WEST SUSSEX COUNTY COUNCIL CONSULTATION

TO:	Arun District Council FAO:Ms M Tomalova
FROM:	WSCC - Highways Authority
DATE:	10 June 2020
LOCATION:	47 South Way Bognor Regis PO21 5EY
SUBJECT:	BE/43/20/PL Demolition of single bungalow & construction of 2 No. semi-detached bungalows & detached single garage.
DATE OF SITE VISIT:	n/a
RECOMMENDATION:	Advice
S106 CONTRIBUTION TOTAL:	n/a

Drawing P01 April 2020 Scale 1:200, 1:500 & 1:1250 @ A3
Proposed Drawing - Site, Block and Location Plans

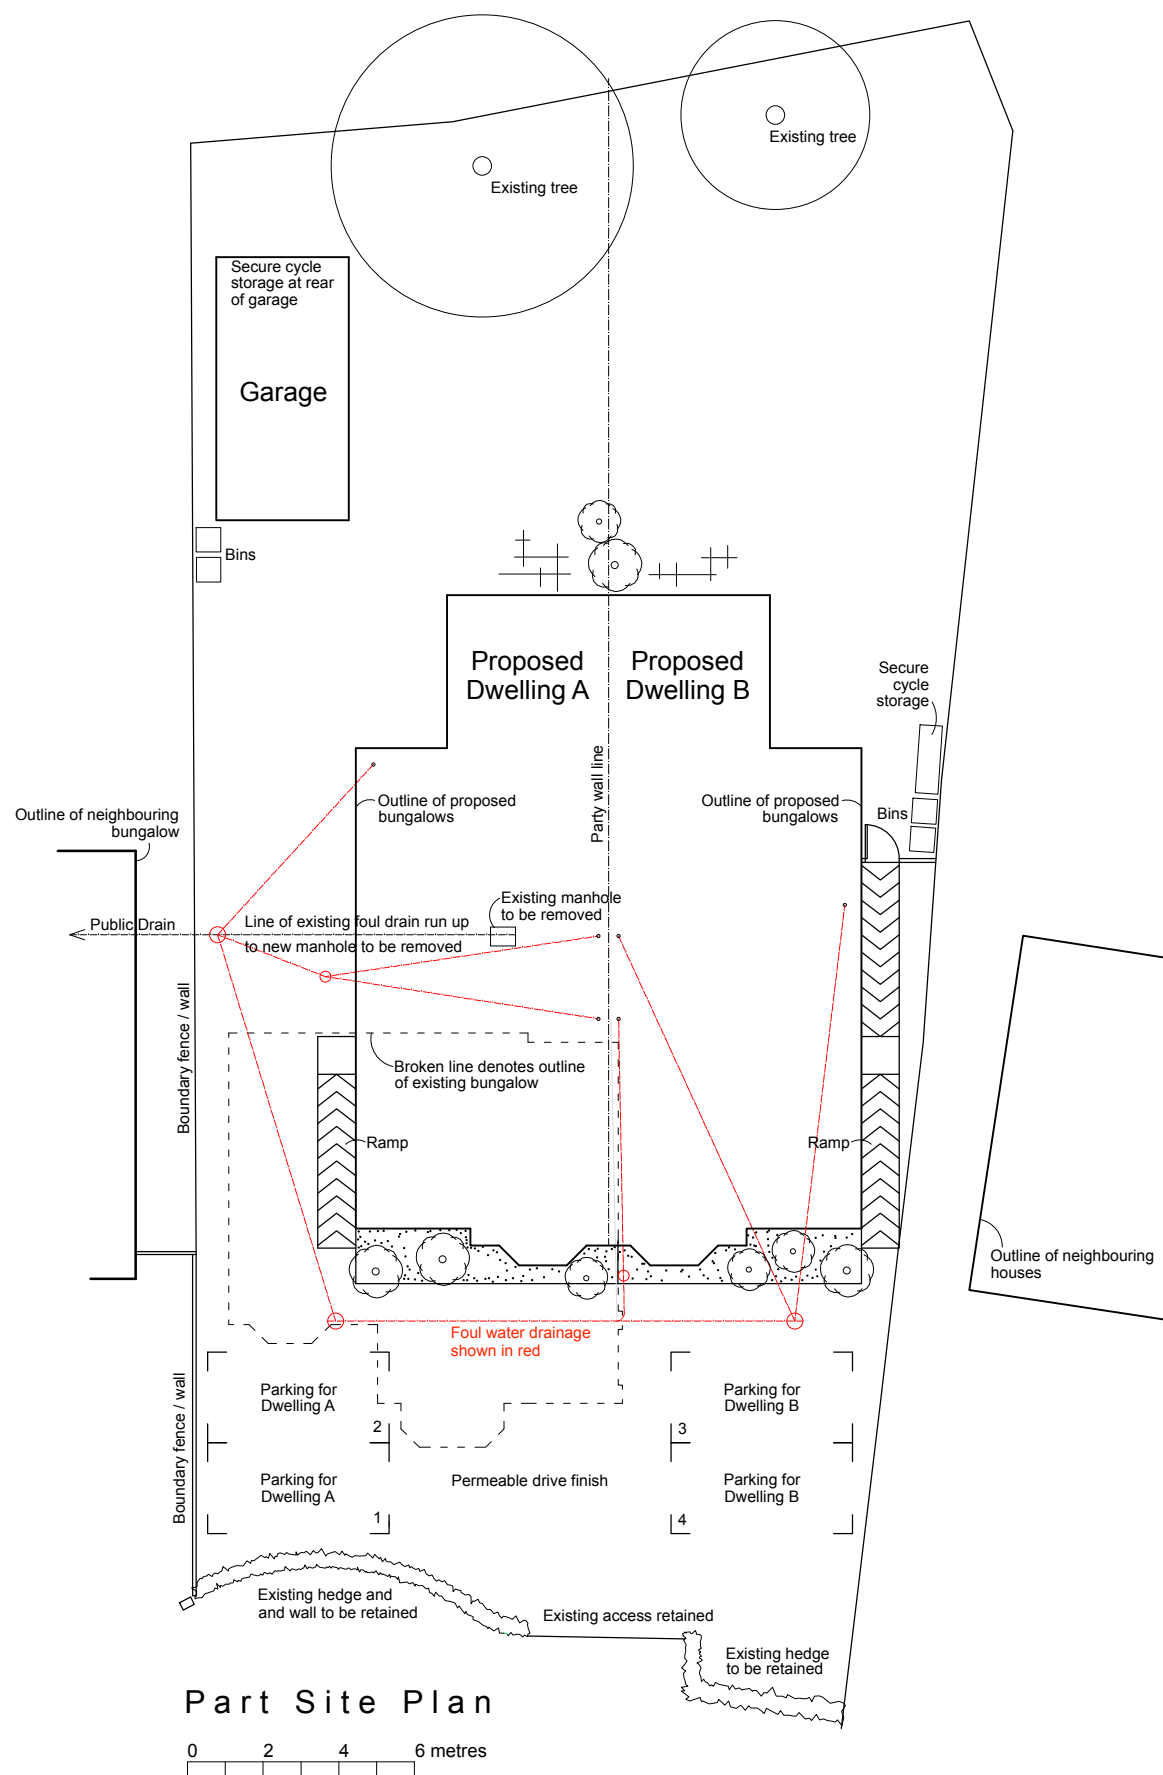
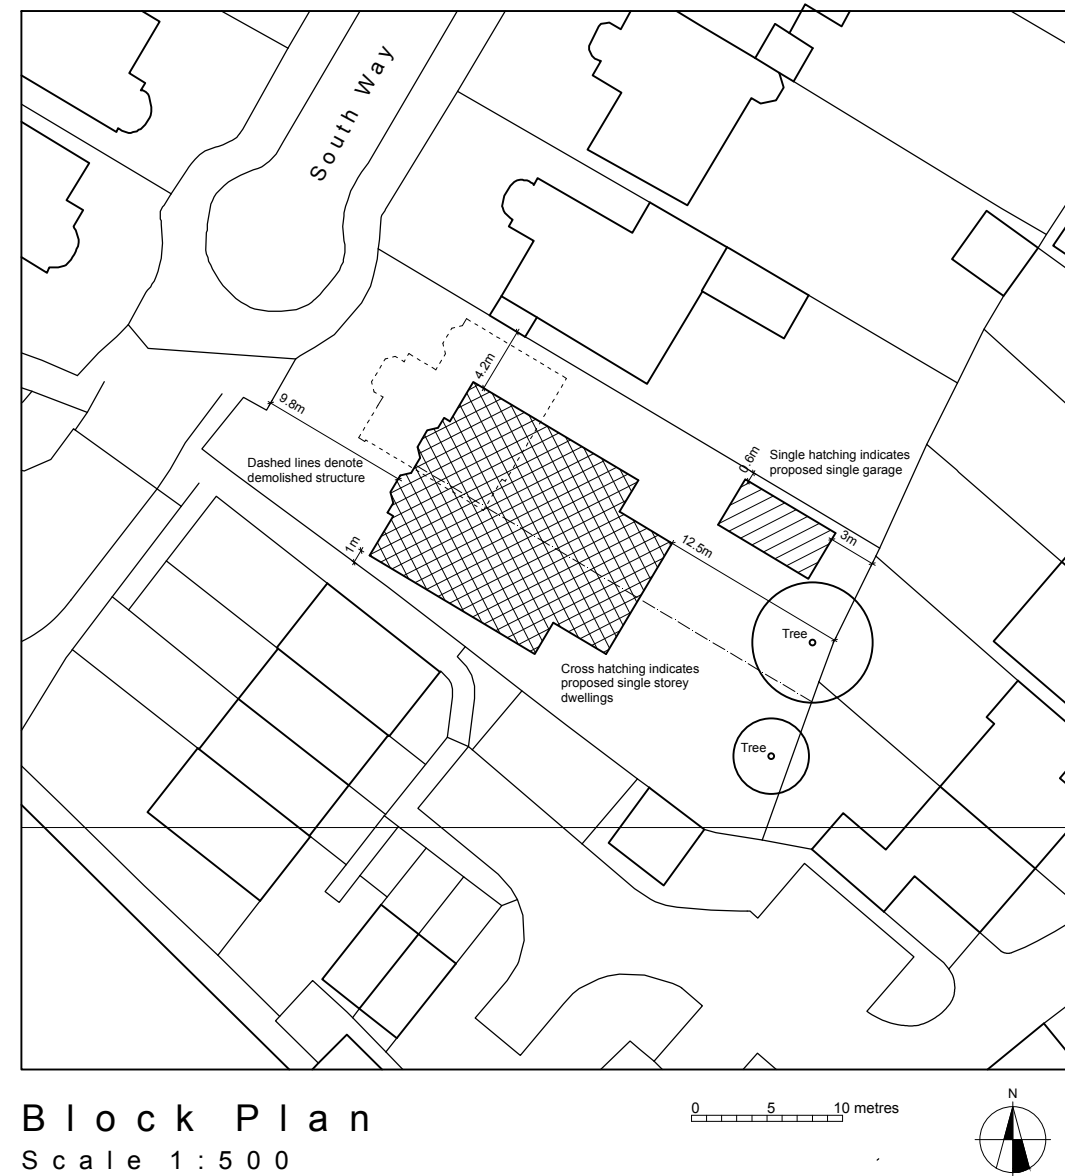
There are 5 parking spaces proposed to serve the new dwellings, 3 parking spaces for proposed dwelling A and 2 parking space for proposed dwelling B. The WSCC Car Parking Demand Calculator would expect 4 parking spaces to be provided for this development, therefore the amount of parking spaces provided is acceptable.

The proposed parking bays have the adequate dimensions of 2.4 x 4.8m as outlined in Manual for Streets (MfS) guidance.

The proposed garage measures 3 x 6.7m internally. Under the revised WSCC parking guidance, each garage space (3 x 6m) counts as 0.5 of a parking space.

The applicant is advised that EV parking spaces should be provided for this development. The amount of EV parking spaces differs between both dwellings as set out below.

The site is situated within residential area in Bersted. The proposed plan annotates spaces for cycle storage which promotes the use of sustainable transport methods and these details are acceptable.

No part of the development shall be first occupied until the car parking has been constructed in accordance with the approved site plan, drawing no PO1. These spaces shall thereafter be retained at all times for their designated purpose.

No part of the development shall be first occupied until covered and secure cycle parking spaces have been provided in accordance with the approved site plan, drawing no PO1.
